**RE: Winrock Redevelopment Dave and Busters
Grading and Drainage Plan
Engineers Stamp Date 9/10/14 (J19D038)**

Based upon the information provided in your submittal received 9-12-14, the above referenced plan is approved for Building Permit and Grading Permit with the following condition and comment:

RE: **Winrock Redevelopment Dave and Busters**
Grading and Drainage Plan
Engineers Stamp Date 8/14/14 (J19D038)

GRADING & DRAINAGE
PLAN

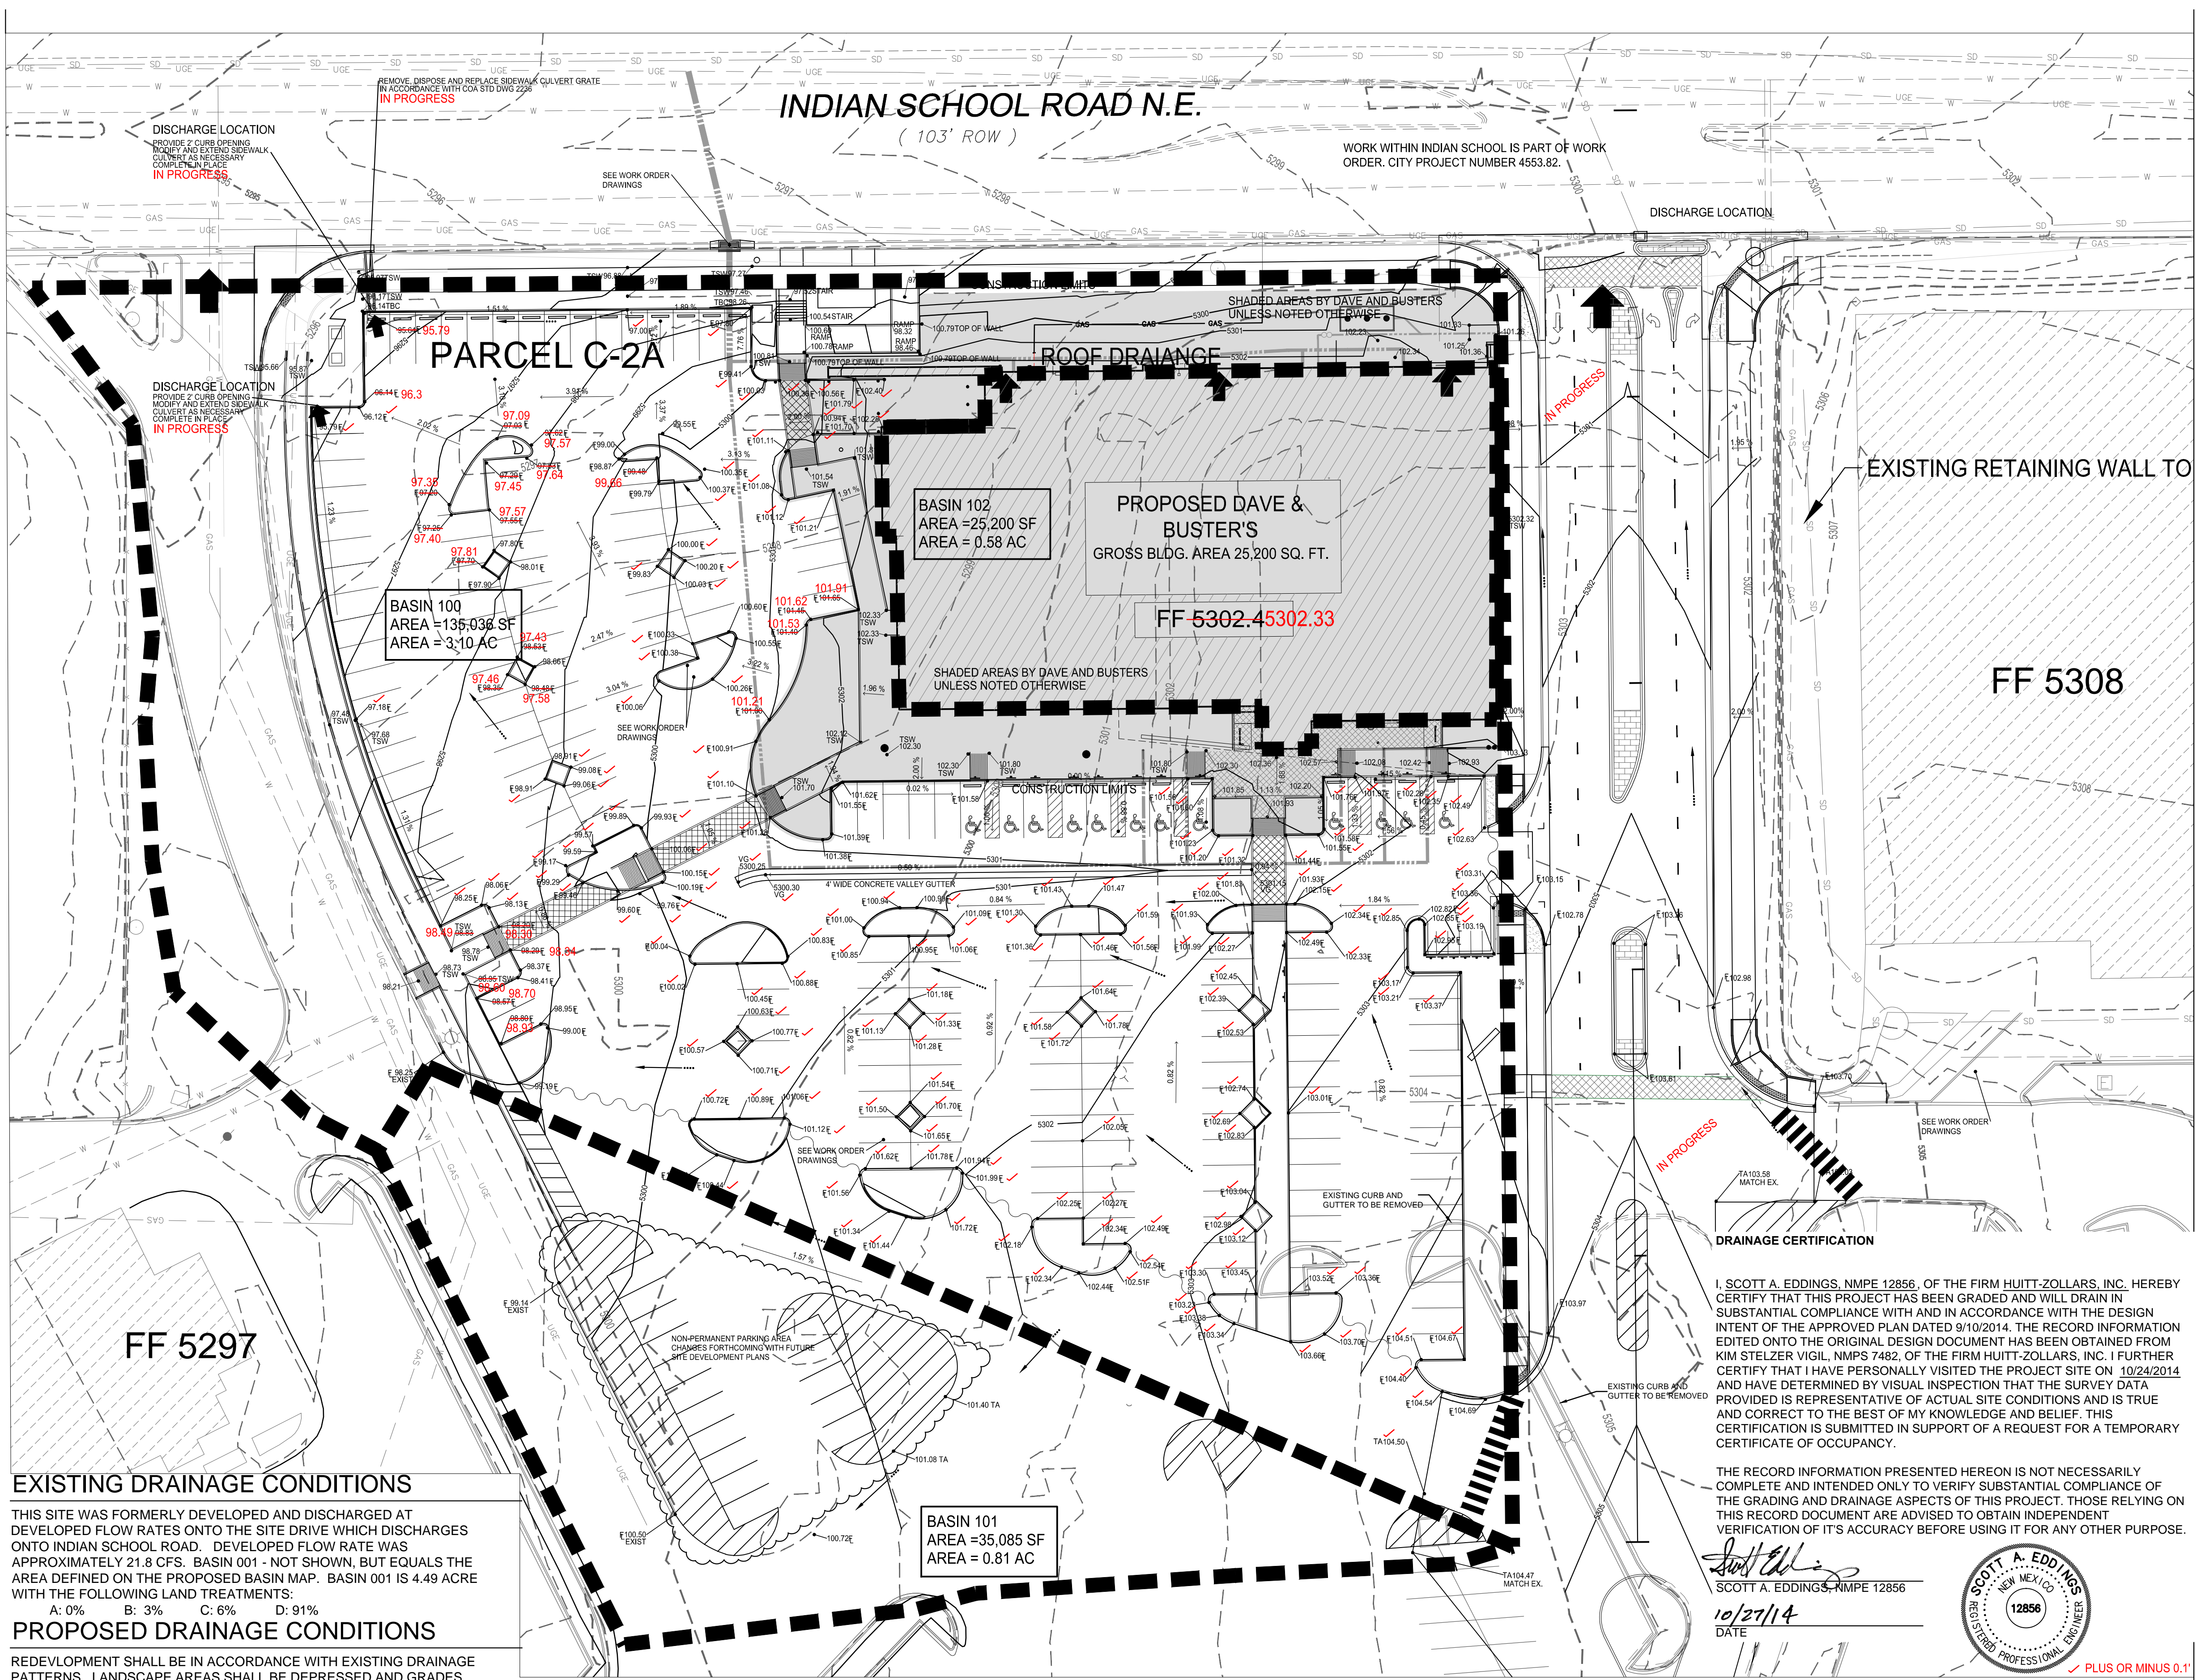
- 1) There appears to be a curb across the new access to the road along the west property boundary. This seems to be a drafting error that needs correction.
- 2) If the road along the west property boundary becomes public in the future, a valley gutter will be required at the west access

1. Regarding the parking islands on the southwest corner: It is not clear whether new parking islands are being built or if striping only. Contour lines extend though these islands, but a return curb would typically be required. - *Noted for future work, SE 9.12.14*

2. Detail all proposed islands along on south side of roadway/driveway showing spot Flowline Elevations. ✓
3. Show a valley gutter and flowline elevations at the new curb returns at the new access. Label streets. - *Project will require reconfigure area in the future, SE 9.12.14*

4. The Flowline Elevations on the parking islands are offset. It appears that the drafting layers are not correctly aligned. ✓
5. I understand that the parking and traffic circulation were amended through an administrative amendment, but there seems to be a discontinuous pedestrian path though the parking island along at the south side of the new access.

6. If the Site Plan is being amended, do the drainage basins delineated on Site Plan SDP-6 (stamp date 10-3-13) still apply to this new condition? *Additional information included, SE 9/12/14*
